Addendum No. 1

RE: Contract ID: C202087

Henderson County (R-0505)

NC-225 From US-25 Near Zirconia To I-26 (US-25 & I-26 Connector)

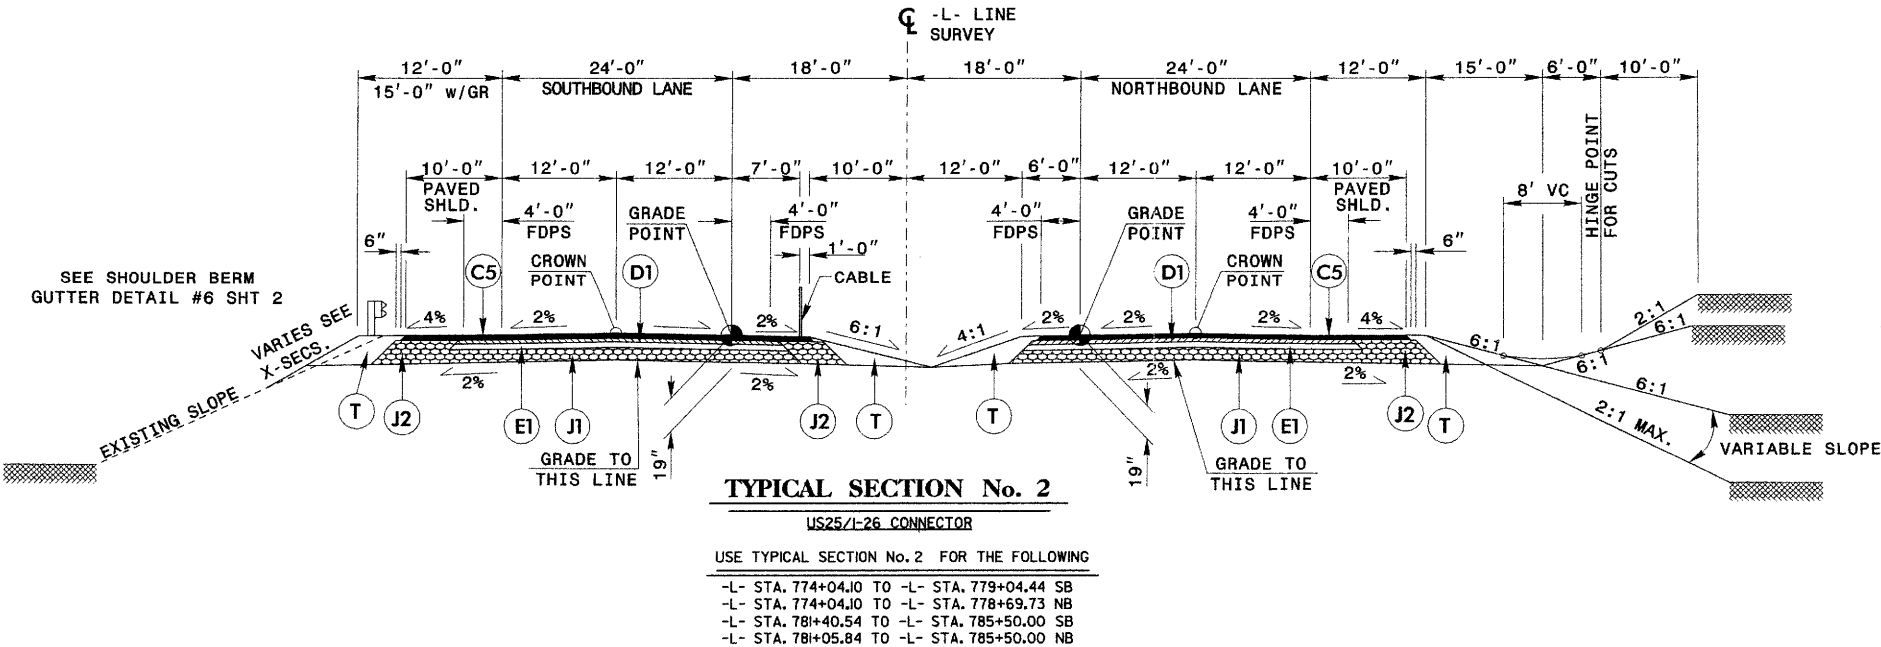
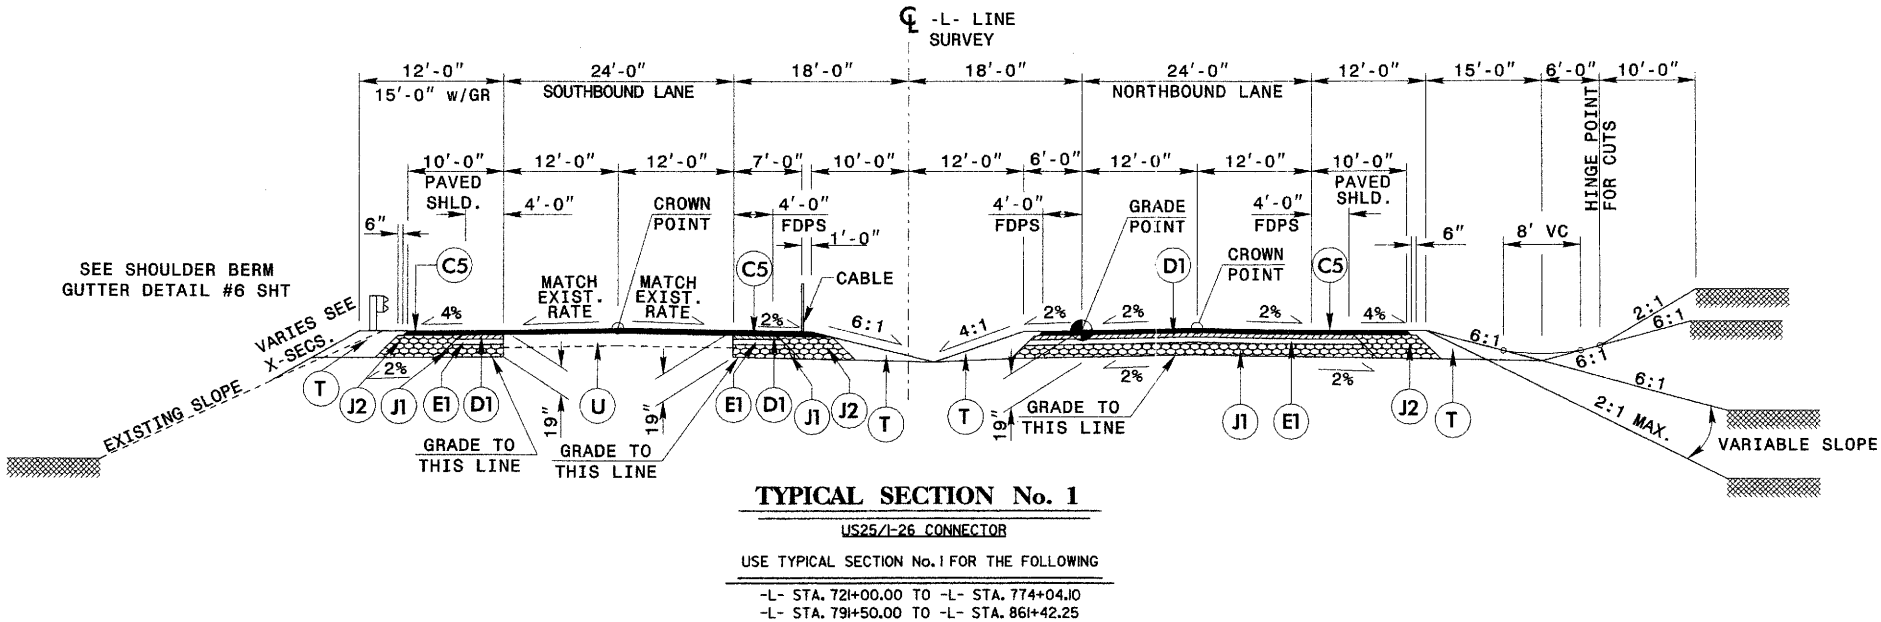
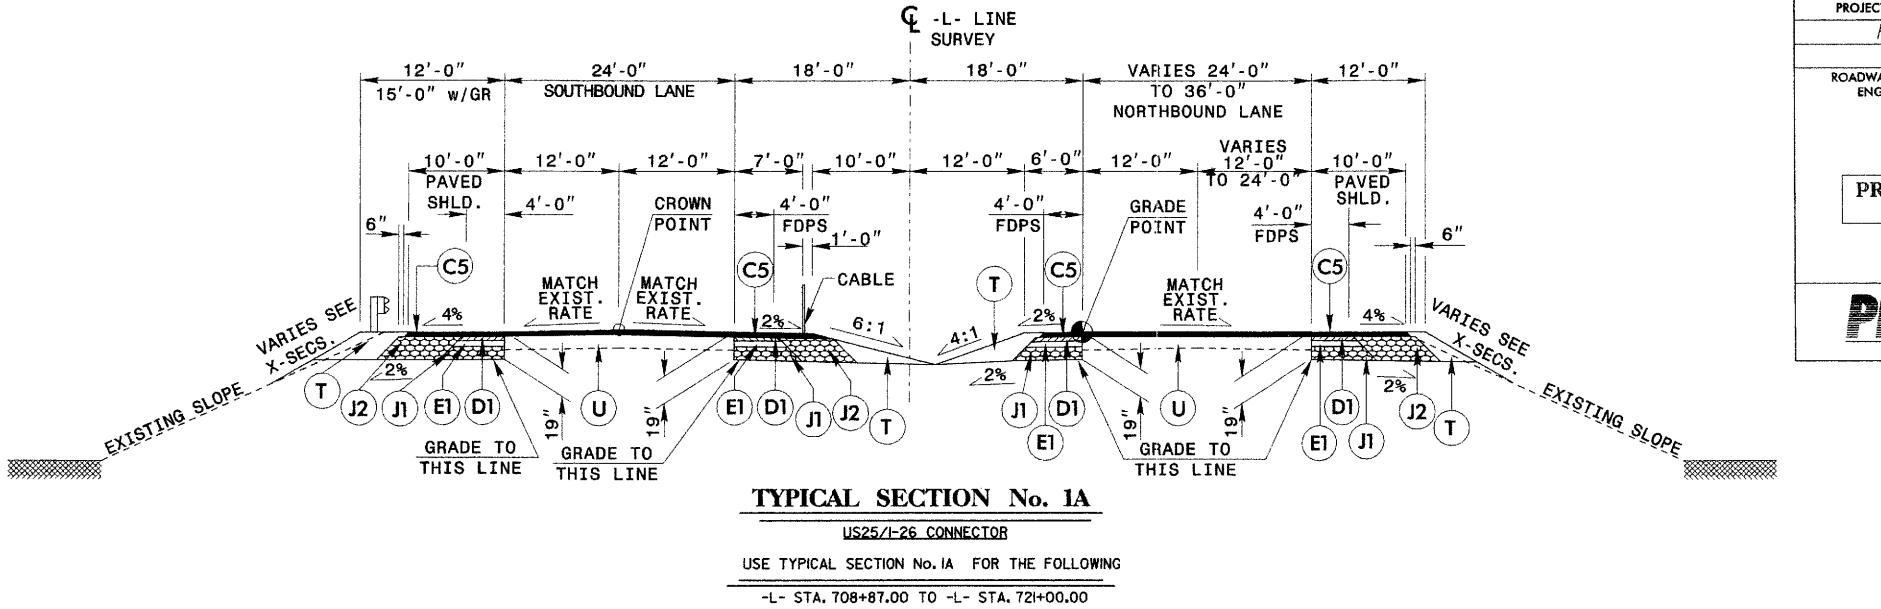
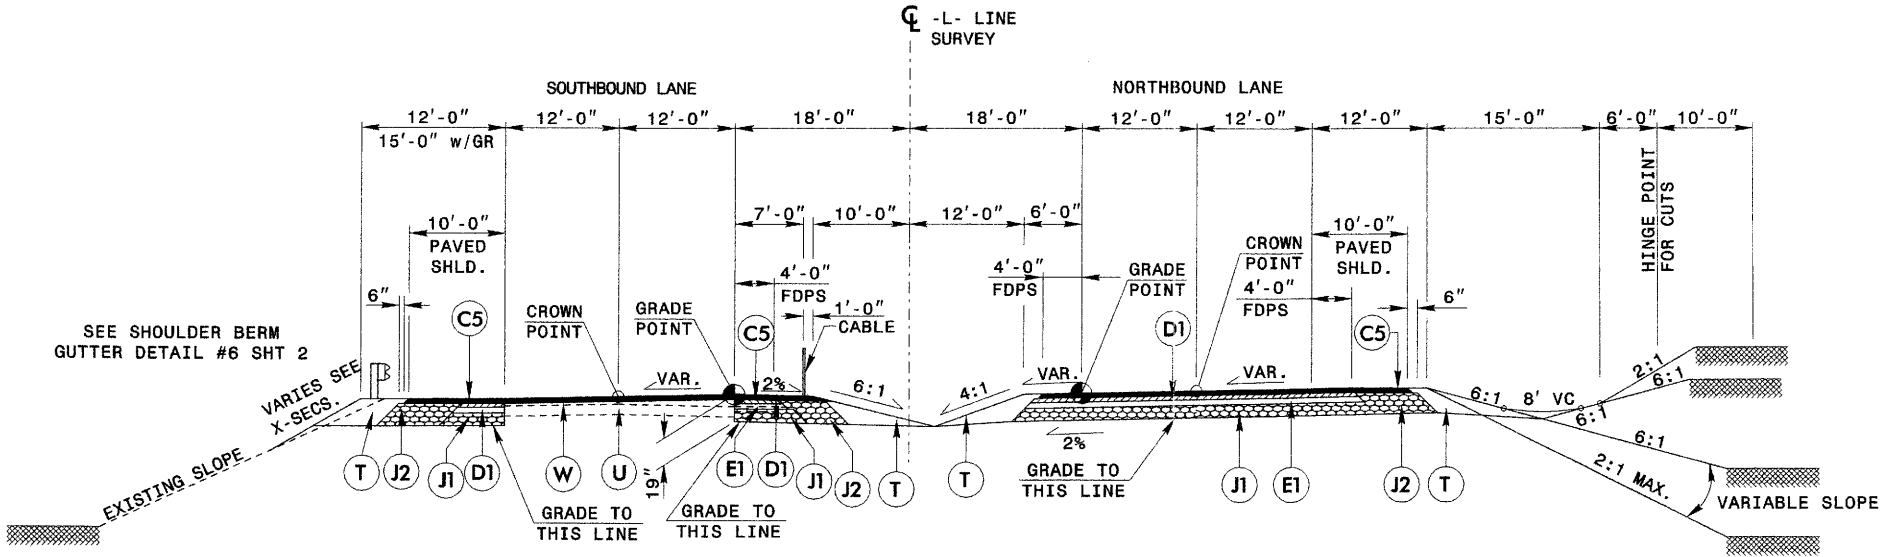
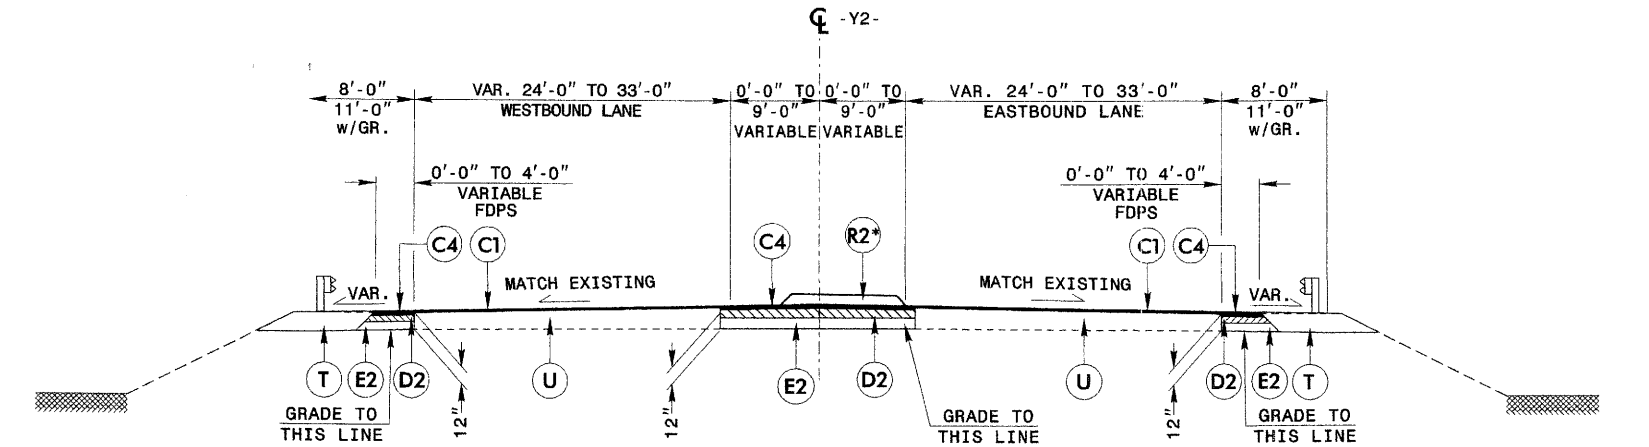
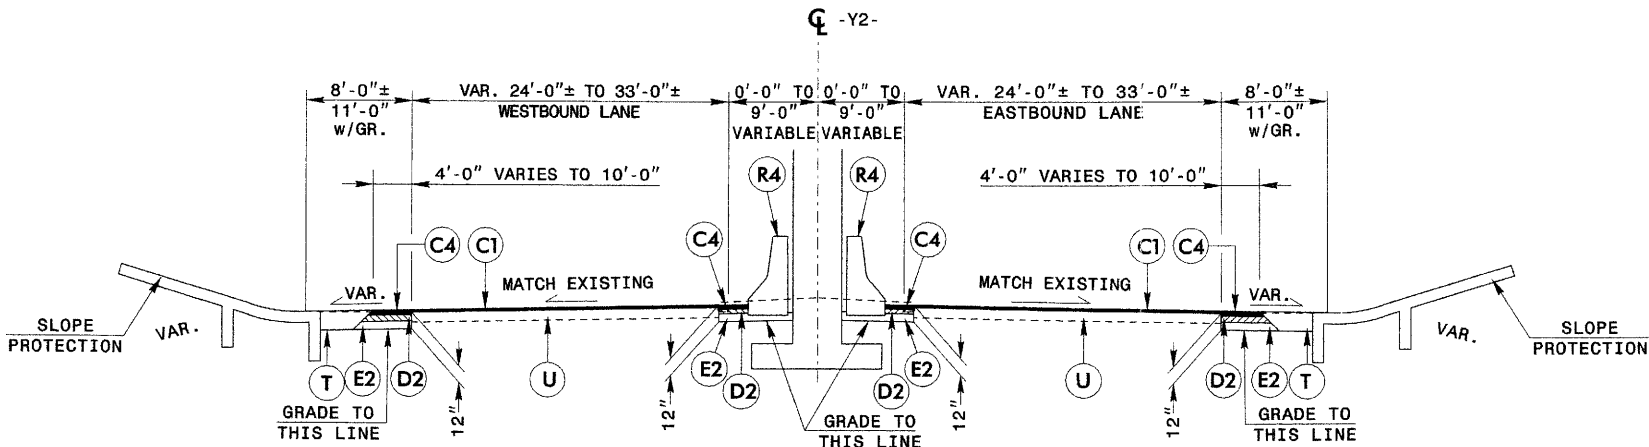
On Sheet Nos. 2, 2-A, 2-B, 2-C, 2-D and 2-E the typical sections and pavement schedules have been revised to change the pavement design and eliminate sub-grade stabilization. Please void Sheet Nos. 2 thru 2-E in your plans and staple the revised Sheet Nos. 2 thru 2-E thereto. It has been determined that the earthwork is not significantly affected and will therefore not be changed.
